OUT19/16377

**Glendell Continued Operations Project (SSD-9349)
EIS Exhibition**

**Glendell Continued Operations Project (SSD-9349)
EIS Exhibition**

Figure 9: Yorks Creek Realignment Conceptual Design

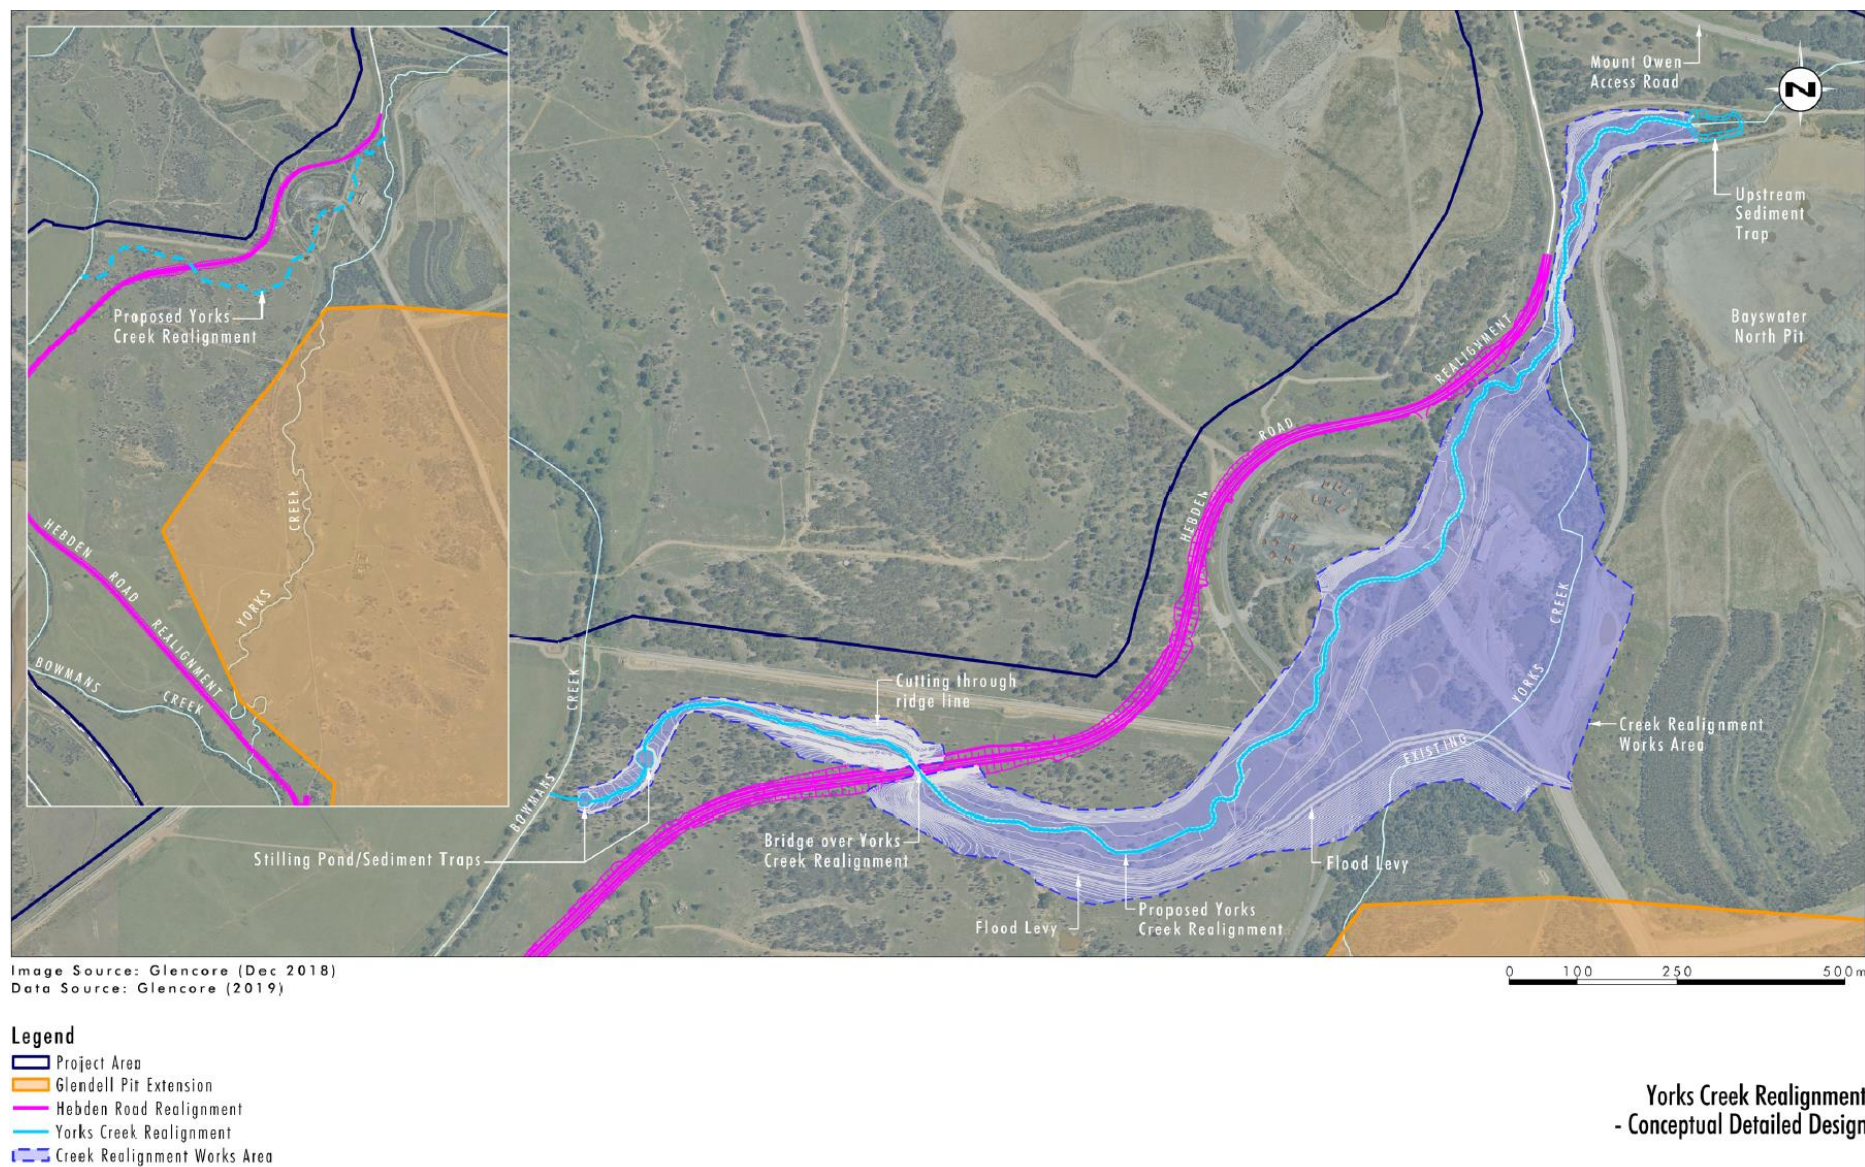
The project proposes to have 2 online sediment basins at the downstream section of the realigned Yorks Creek. It is noted that online basins are not permitted on 3rd order streams and above according to the Guidelines for Controlled Activities on Waterfront Land (NRAR 2019). Furthermore, new in-river dams on 3rd order streams and above are prohibited in the Glennies Water Source in the Water Sharing Plan for the Hunter Unregulated and Alluvial Water Sources 2009.

- Yorks Creek diversion is to be consistent with the Guidelines for Controlled Activities on Waterfront Land (NRAR 2019), and include (but not limited to) a Vegetated Riparian Zone of 30 metres from top of bank;
- Prepare a final watercourse design and construction plan for the Yorks Creek diversion following the ACARP 2002 and Queensland government (DNRM 2014) guideline, and consistent with the design objectives outlined by Fluvial Systems (2019), and incorporate it into the final landform plan for the mine;
- Identify and report on the hydrologic stress and geomorphic alteration occurring due to the diversion of Yorks Creek;
- Investigate options for water release into Yorks Creek to enhance geomorphic processes; and
- Undertake performance monitoring and reporting of the Yorks Creek diversion following *A Rehabilitation Manual for Australian Streams* by Rutherford et al 2000.
